CITY OF ALBUQUERQUE

September 20, 2021

**Re: Kiddie Academy
4590 Paradise Blvd
30-Day Temporary Certificate of Occupancy
Transportation Development Final Inspection**
Engineer's/Architect's Stamp dated 6-17-20 (C12D003A)
Certification dated 9-16-21

**A1 TRAFFIC CIRCULATION LAYOUT PLAN**  
 SCALE: 1/8" = 1'-0"

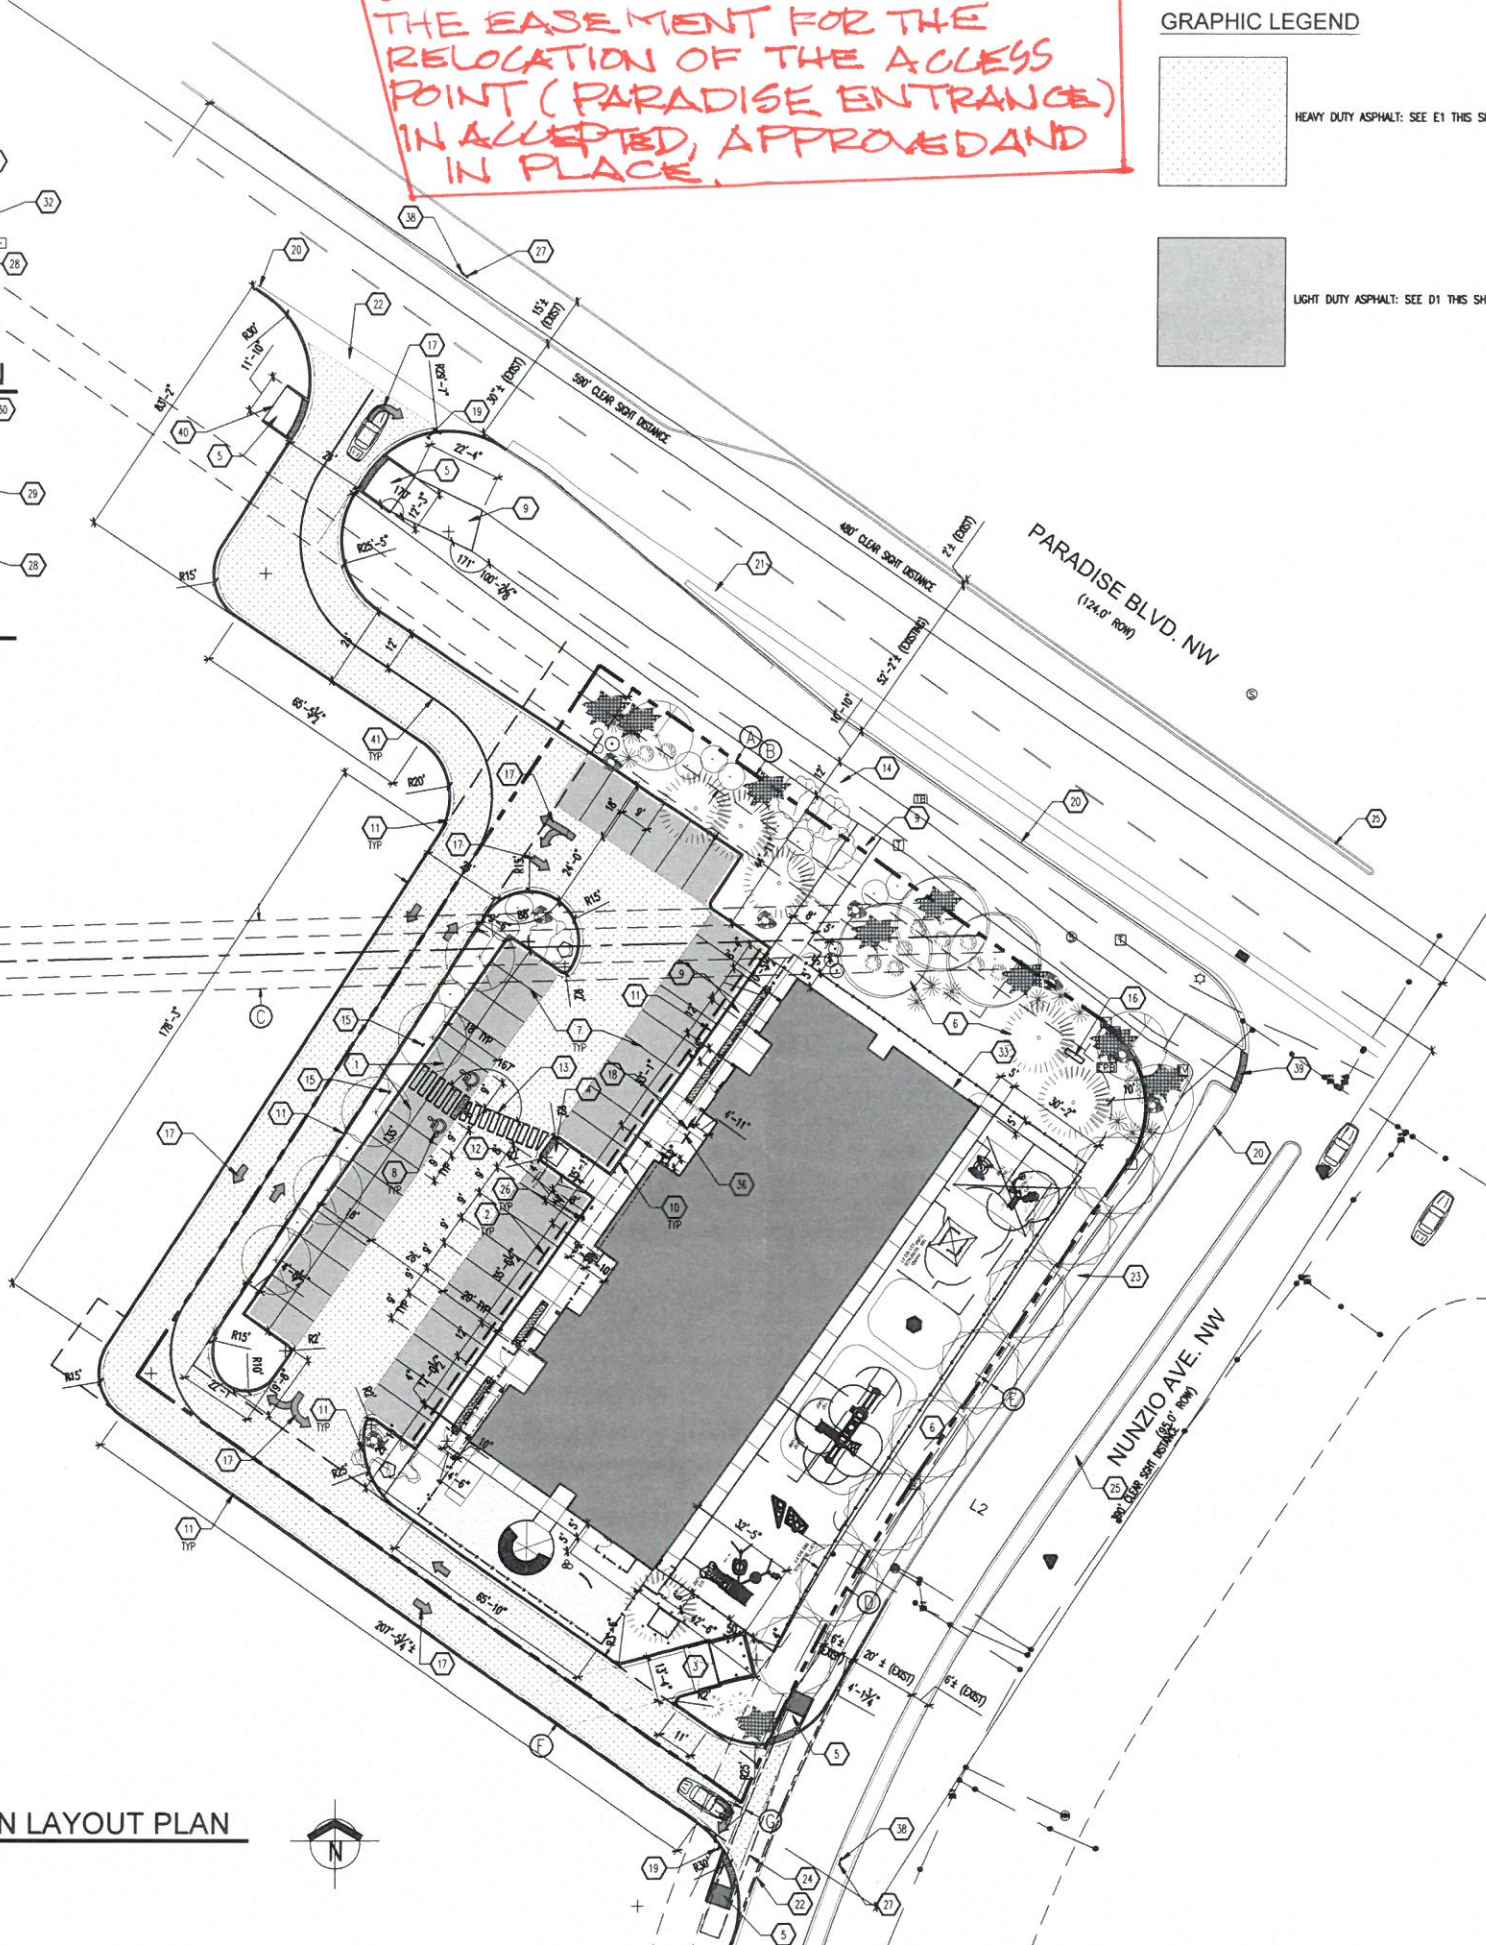
- Please provide approved access easement as stated on approved TCL.
- Remove Construction Debris and equipment from site.
- Pathway from public right of way to building entrance is blocked by Pillar (minimum 4 foot required clearance around Pillar)
